**BCA Assessment Report**

**Phase 2 - State Significant  
Development Application (SSDA)  
Documentation**

Walsh Bay Arts Precinct  
Pier 2 & 3 + Wharf 4 & 5, Waterfront Square

Prepared for: Infrastructure NSW  
Ref: 160144  
Date: November 2016

Figure 17: Pier 2/3 Level 2 egress

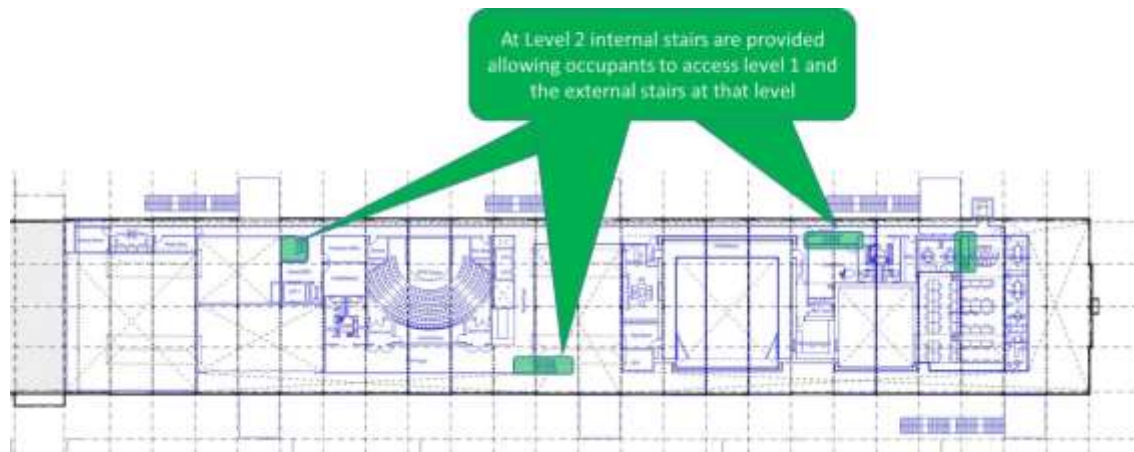
25.	D1.4	<p>Exit travel distances generally comply throughout the building with the exception of the following:</p> <p><b>Pier 2/3 -</b></p> <ul style="list-style-type: none"> <li>+ <b>Level 1</b> - Up to 48m worst case to one of two alternative exits in lieu of 40m from the Chair store, Rehearsal store and Bell rehearsal 1 areas.</li> </ul> <p><b>Note 1:</b> Egress from the Bar store and bar area will need to be confirmed.</p> <p><b>Note 2:</b> Refer also comments below with respect of extended travel distances within the ATYP theatre space.</p> <ul style="list-style-type: none"> <li>+ <b>Level 2</b> - Up to 34m to a point of choice between alternative exits worst case in lieu of 20m when measured from Dimmer Room, ATYP theatre and the female sanitary facilities</li> <li>+ Up to 48m to one of two alternative exits in lieu of 40m when measured from the rack room.</li> </ul> <p><b>Wharf 4/5</b></p> <ul style="list-style-type: none"> <li>+ <b>Ground Floor</b> - Up to 22m to a point of choice between alternative exits worst case when measured from Costume making/laundry space</li> </ul> <p>In light of the above, it is clear that further plan amendments will be required to address the extended travel to Lv2, given the extent of the extended travel distances.</p> <p>Notwithstanding, we note that it is expected that the projects Fire Engineer will rationalise extended travel within the building as the design progresses and in this regard further consultation will be required accordingly.</p>

26.	D1.5	<p>Distances between alternative exits will generally comply throughout the building with the exception of the following:</p> <p><b>Pier 2/3 -</b></p> <ul style="list-style-type: none"> <li>+ <b>Level 1</b> - Up to 80m worst case between alternative exits when measured back through the point of choice from the rehearsal store area.</li> <li>+ <b>Level 2</b> - Up to 66m between alternative exits in lieu of 60m when measured through the ACO balcony area.</li> </ul> <p><i>The above extended travel distances will need to be rationalised by the projects Fire Safety Engineer accordingly.</i></p>

3.4.3 Wharf 4/5

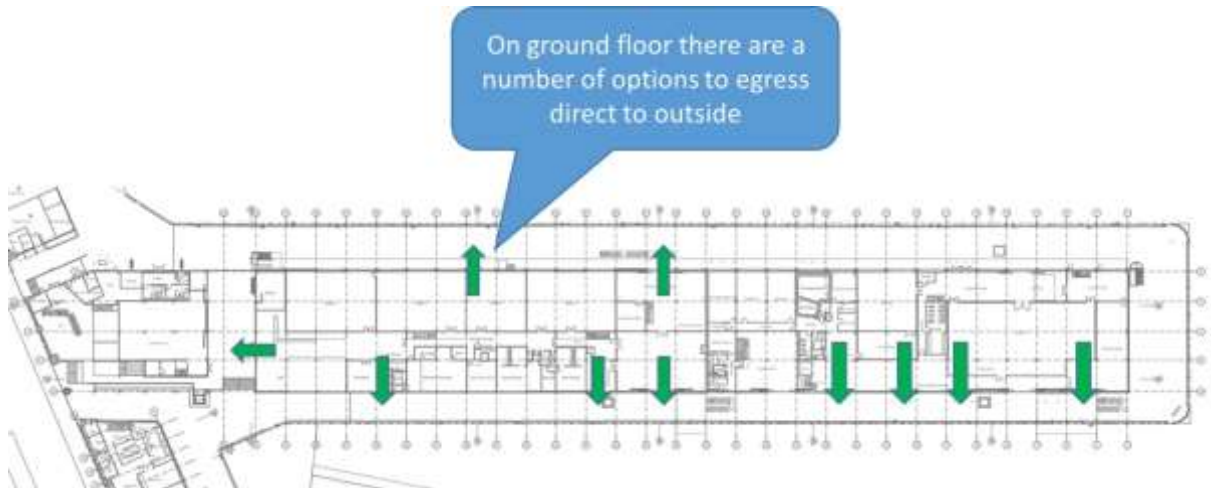
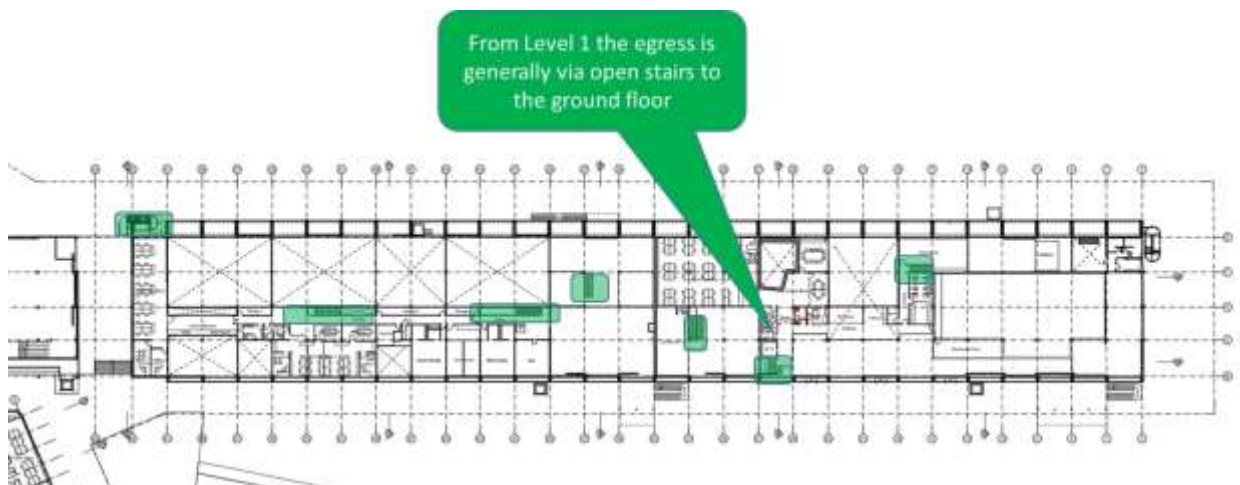
34.	E1.3	It is clear that the existing hydrant outlets to Wharf 4/5 will need to be addressed by the projects Fire Safety Engineer given their location being less than 10m from the building served.
